From: Roger Spencer
Sent: 02 November 2012 12:23
To: Planningecons
Subject: FW: Planning Consultation on: P/84/12/

APPLICATION P/84/12/

Site Address: Car Park Land off Sandy Road Pagham PO21 4SP

Description of Works: New access road & amendment to curtilage of Plot 1 -
amendment to approval P/44/09/ (re-submission following
refusal P/30/12/)

EXTRACT FROM APPROVED PLAN NO P 44/09

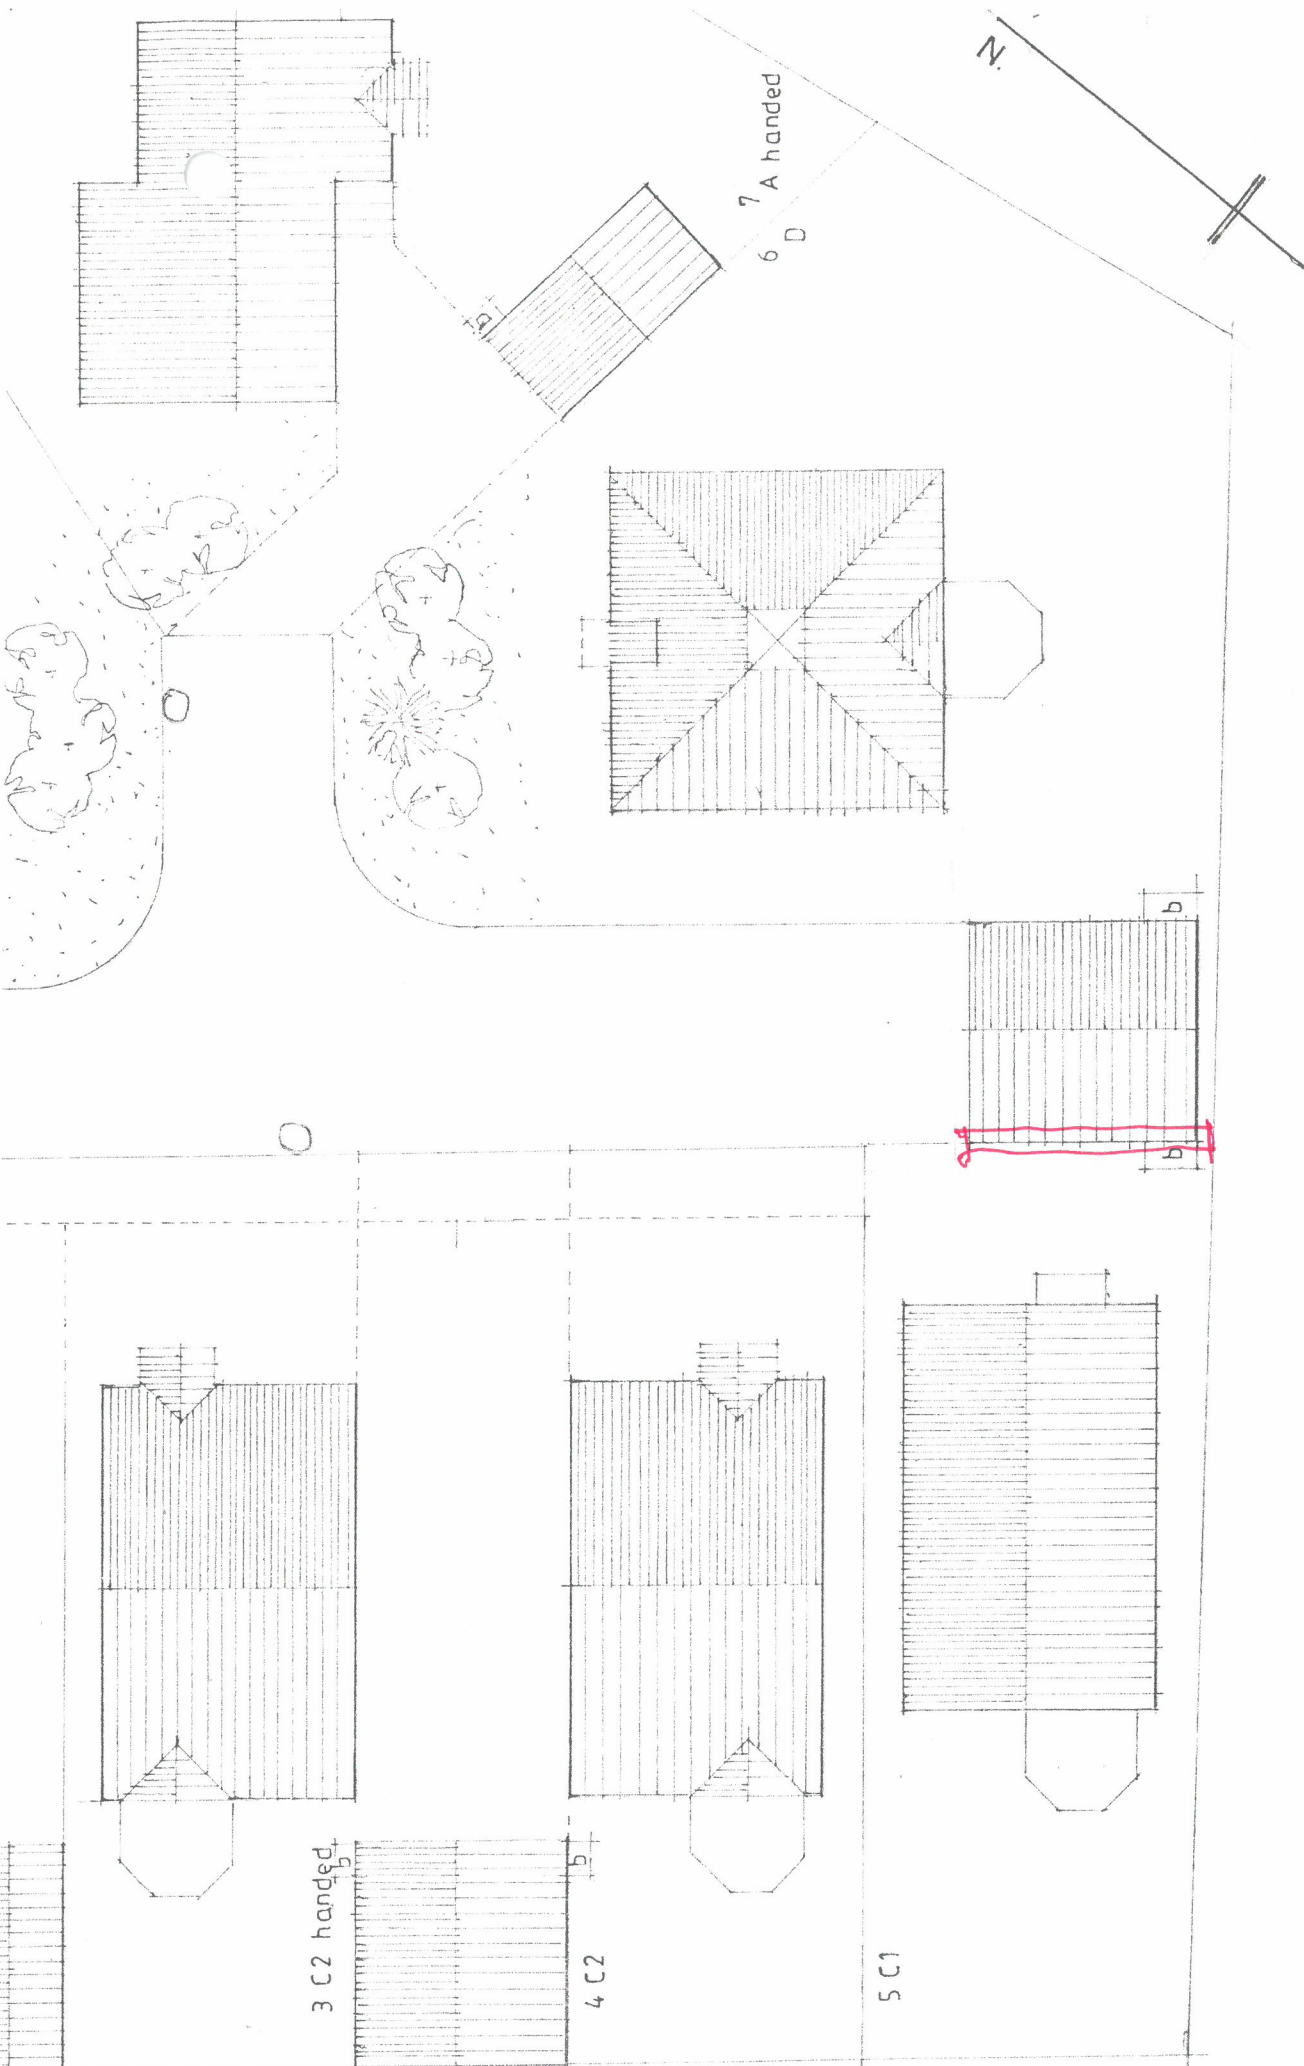
To confirm our telephone conversation today; the concern raised in my response to the consultation for the above application was in relation to the lack of notes on the drawing (002 rev A) to confirm that the two gates adjacent to the storm walls are to be storm gates capable of preventing the flow of overtopping water to a depth of 600mm.

On the original application FRA the wall to the southwest of the building was shown as a full width wall (there was a gate 'arc' shown but this not annotated as a gate. I have no concern if the width between building and boundary at this point is part wall / part gate.

The gates should be self closing and provide positive leak-proofing (ie close under water pressure onto a seal). The frame or jambs should be sealed to the adjoining.

The boundary wall (to Two Decks) was shown in the original application FRA as also being a flood barrier wall. Whilst I would not be averse to this, I do not consider this to be absolutely necessary.
